Final Acceptance (FA) Punchlist
EPC - DPW - Stormwater Section

Project Name:	Lorson Ranch East F1
EDARP Filing Number(s):	SF188, CON1958
ESQCP Number:	ESQ182
Attendees:	DPW SW: Natasha Grimaldo Developer: N/A
Date of Walk-Thru:	11-13-2023
Walk-Thru Number:	4 th

DATE:  
JUNE 12, 2018

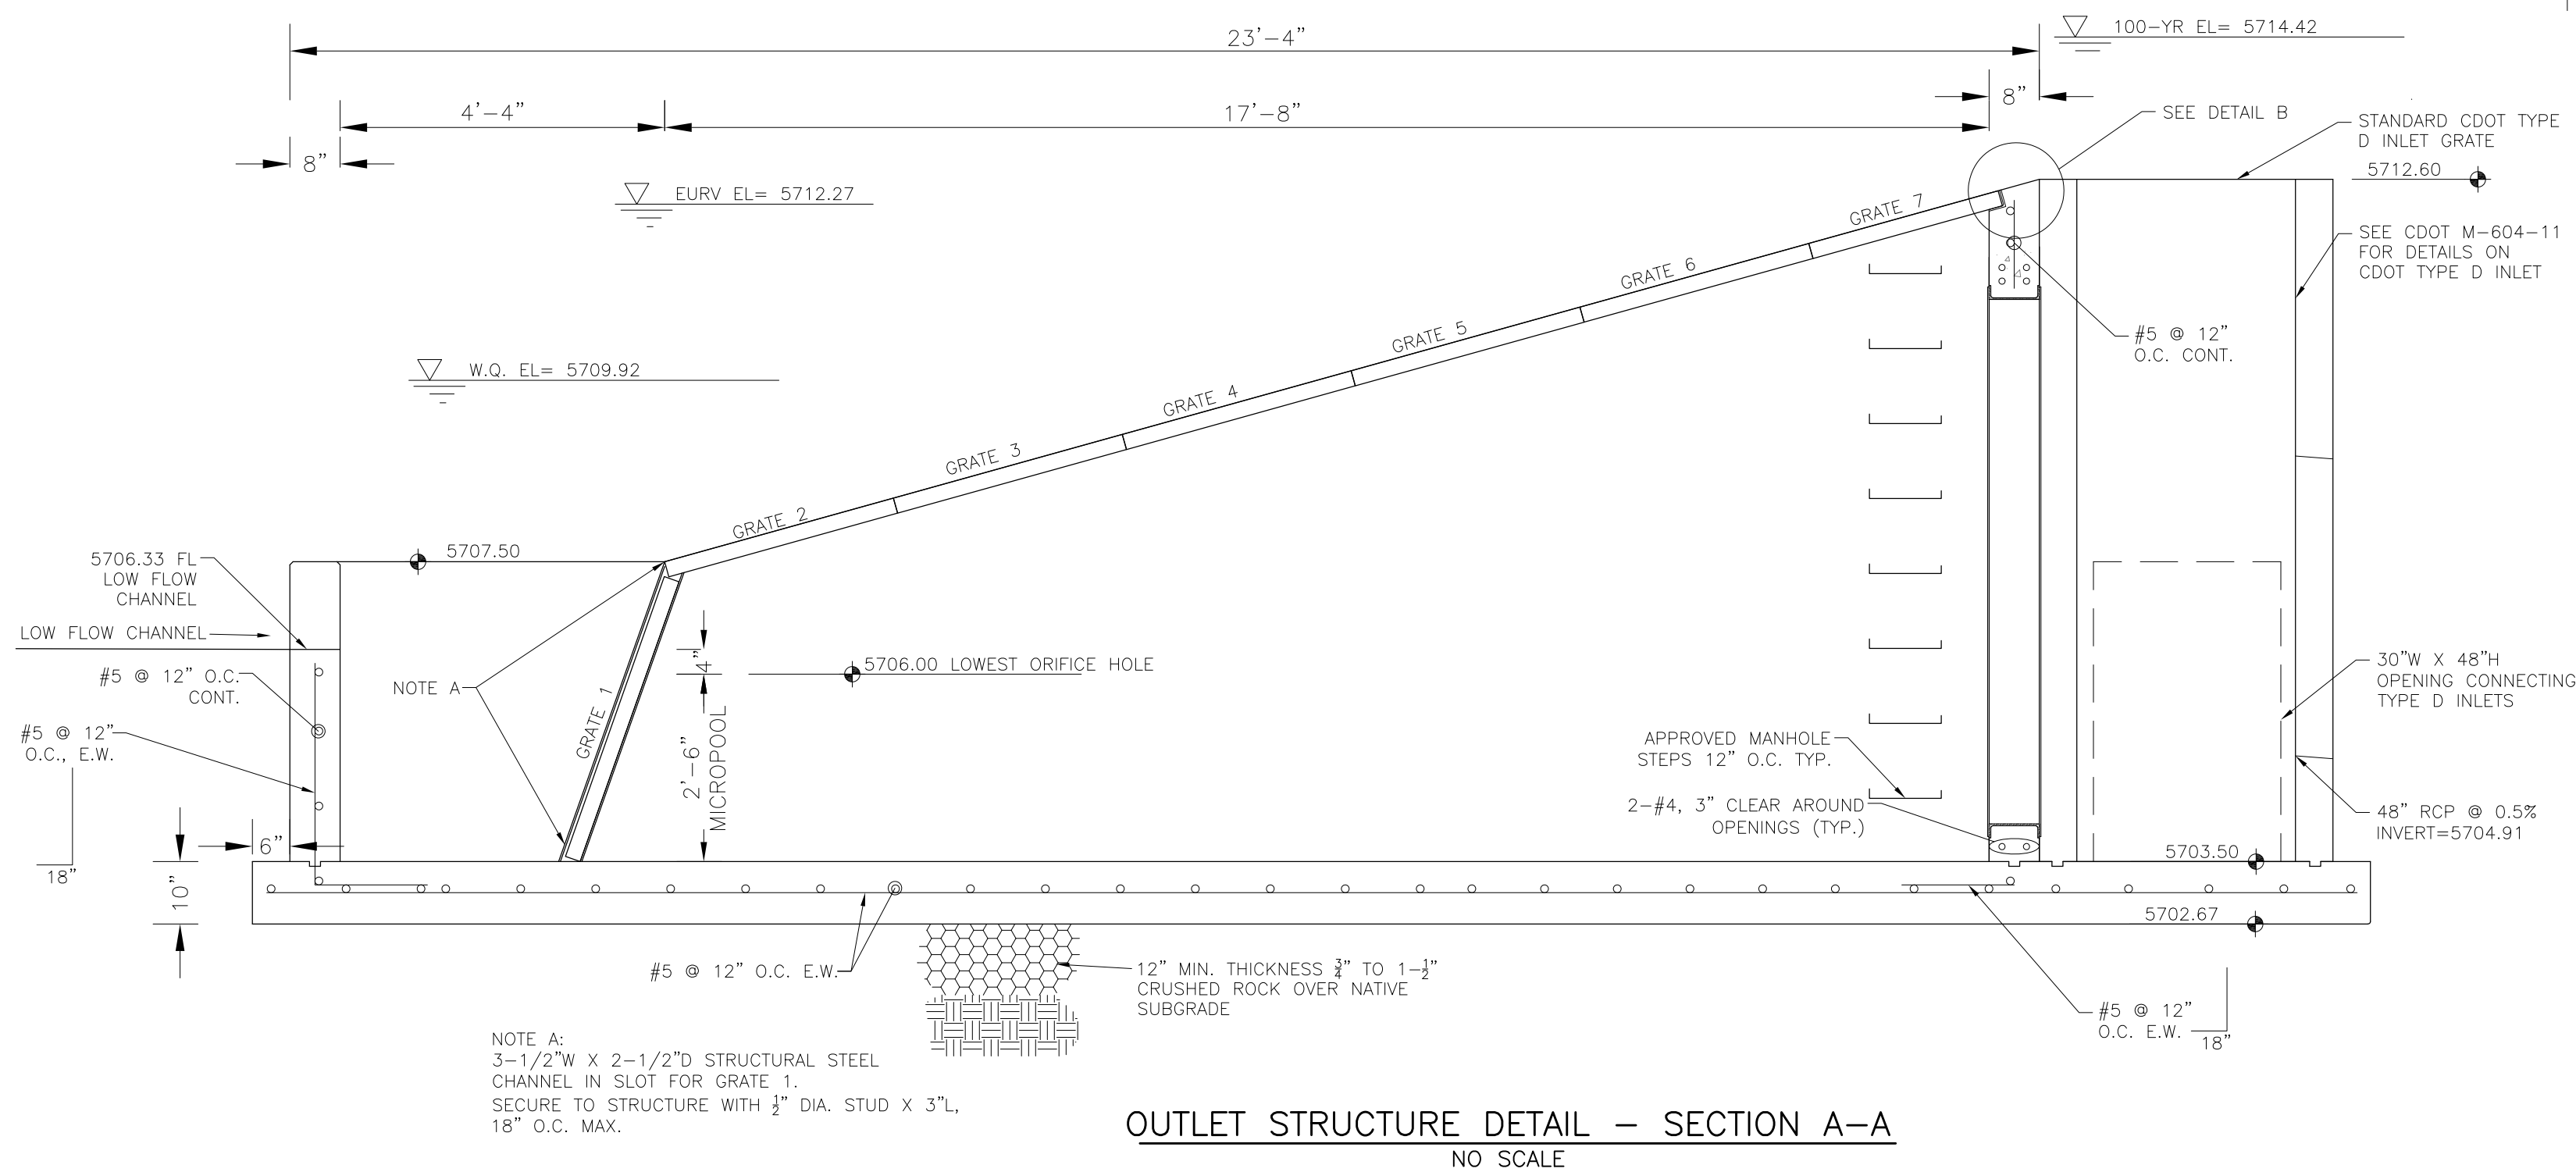
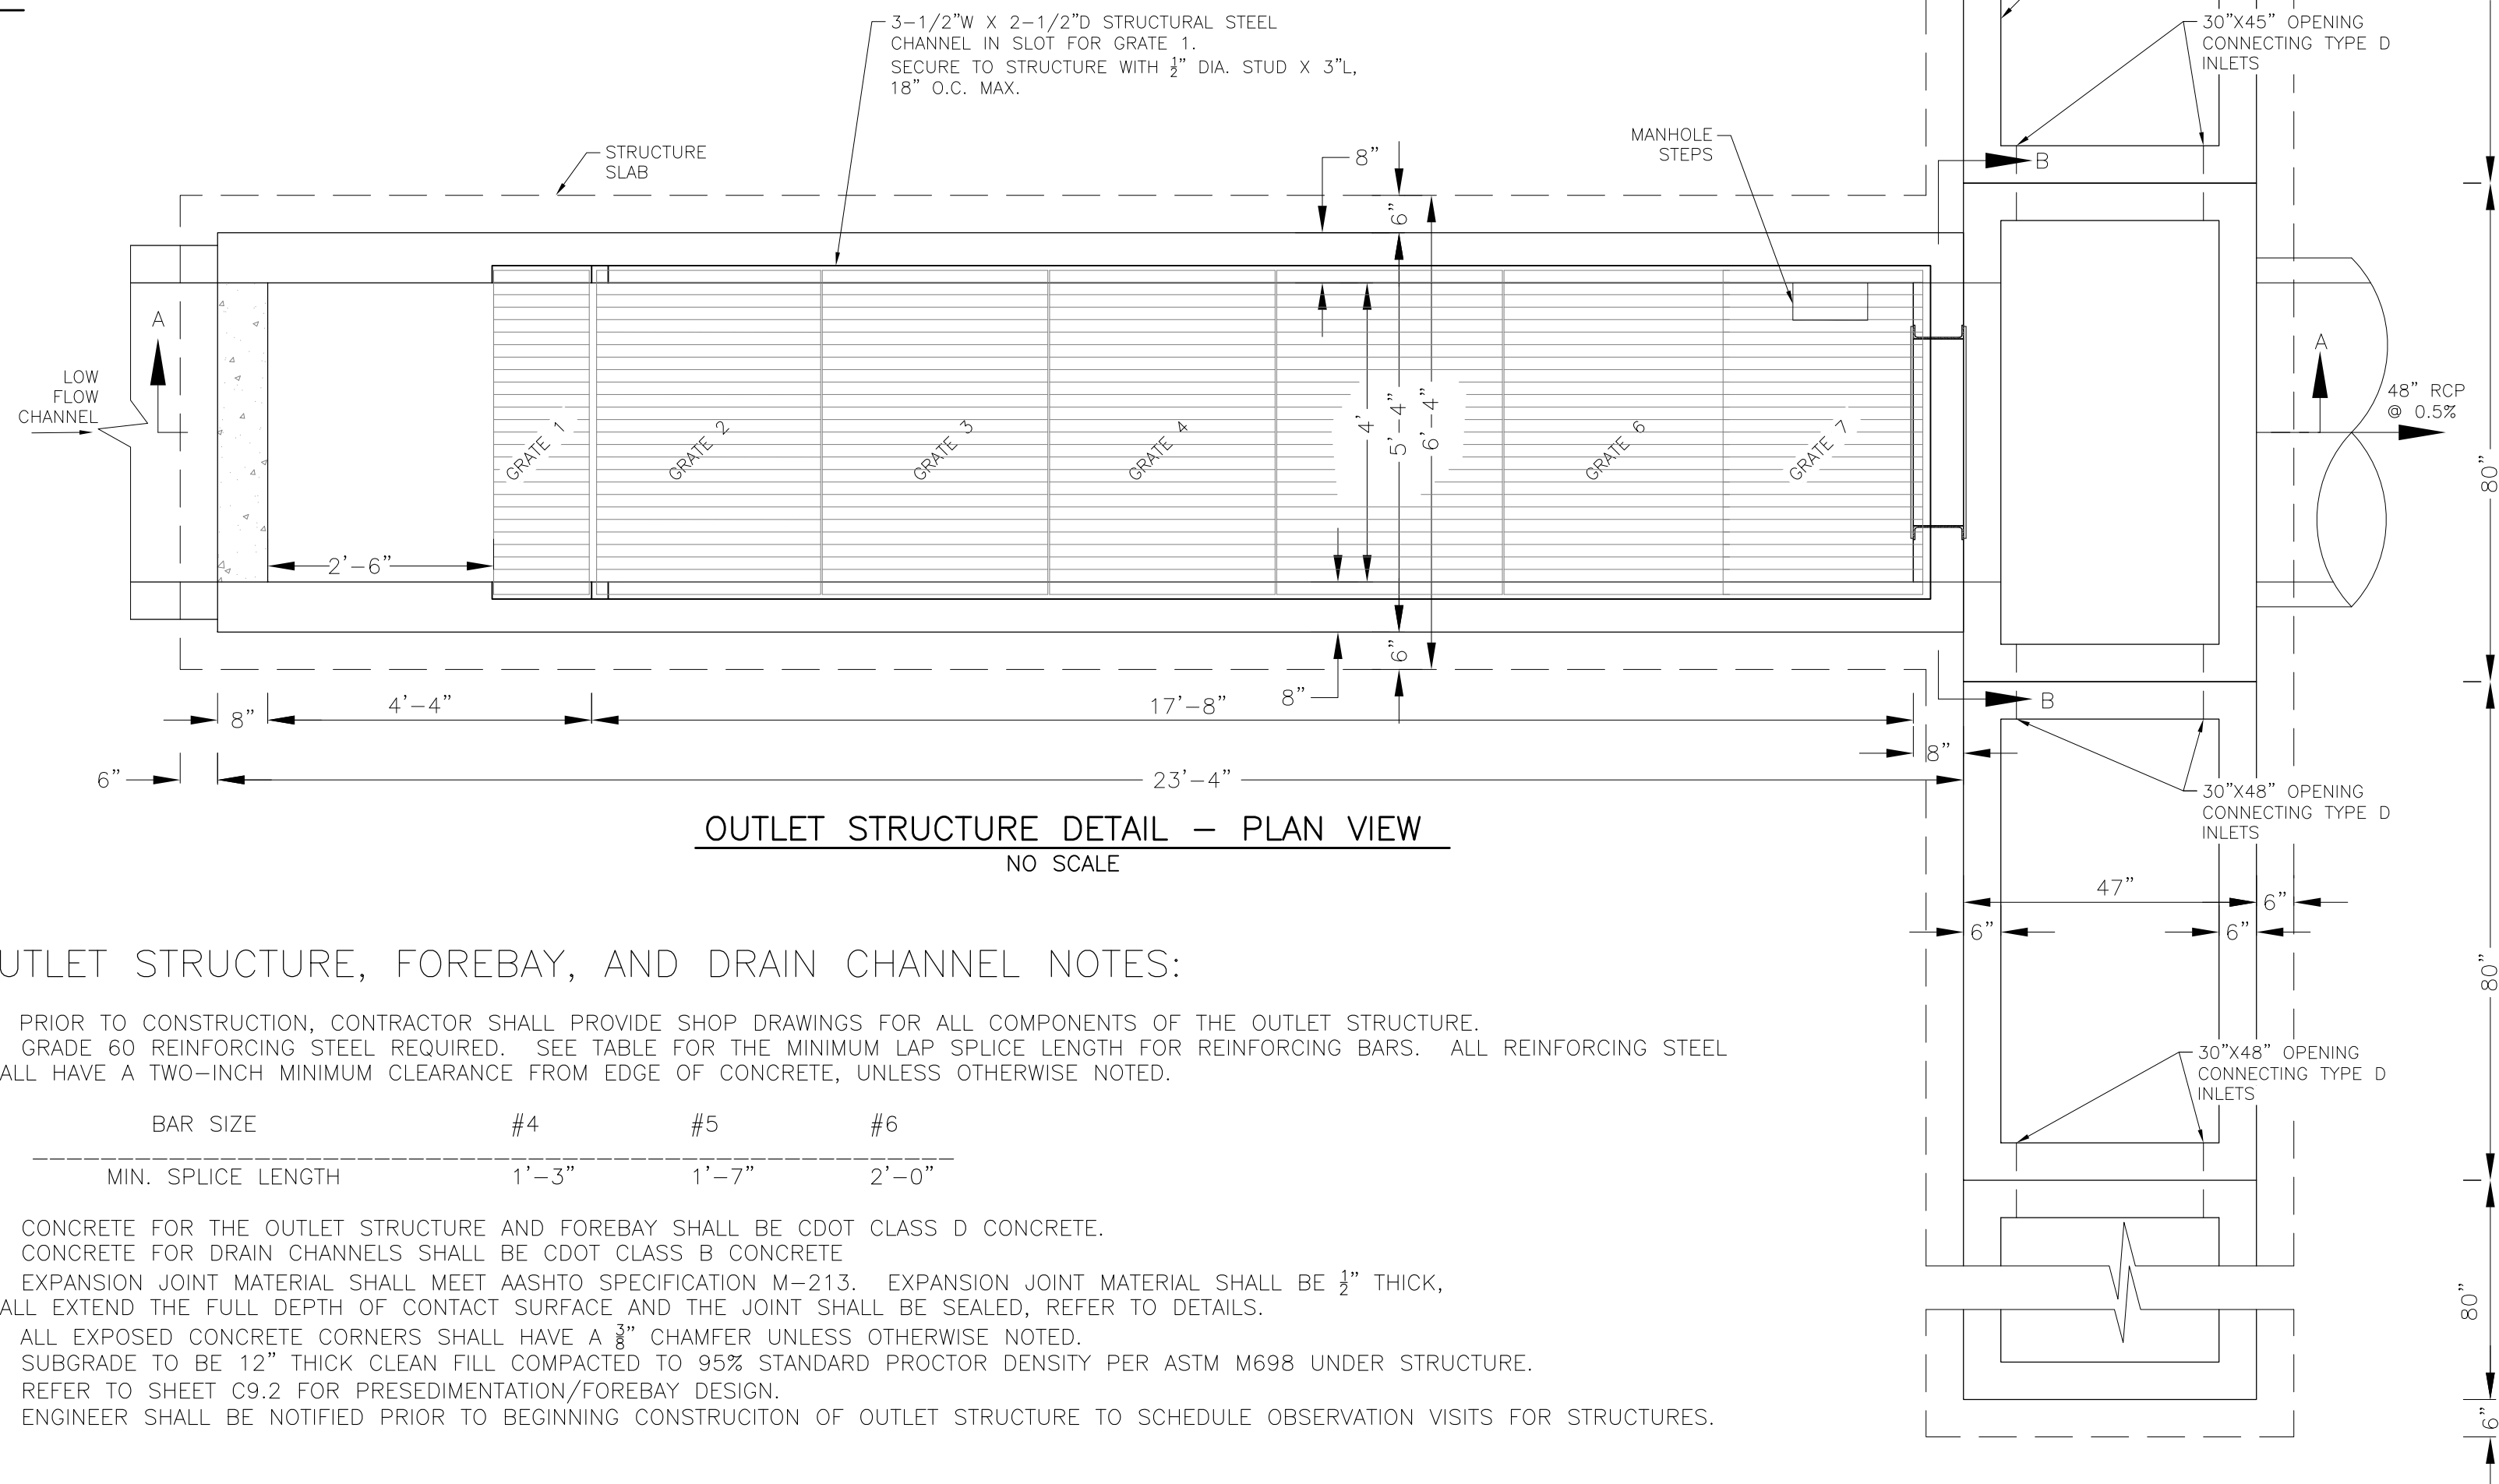
- Repair cracks in forebays and trickle channels.
- Remove sediment and debris from outlet pipe.
- Remove rock sock from forebay notch in forebay B.
- Implement 9" D50 soil rip rap per specification on forebay A and B. Reference sheet C9.2 of CDs (or show engineered approved deviation on As-builts).
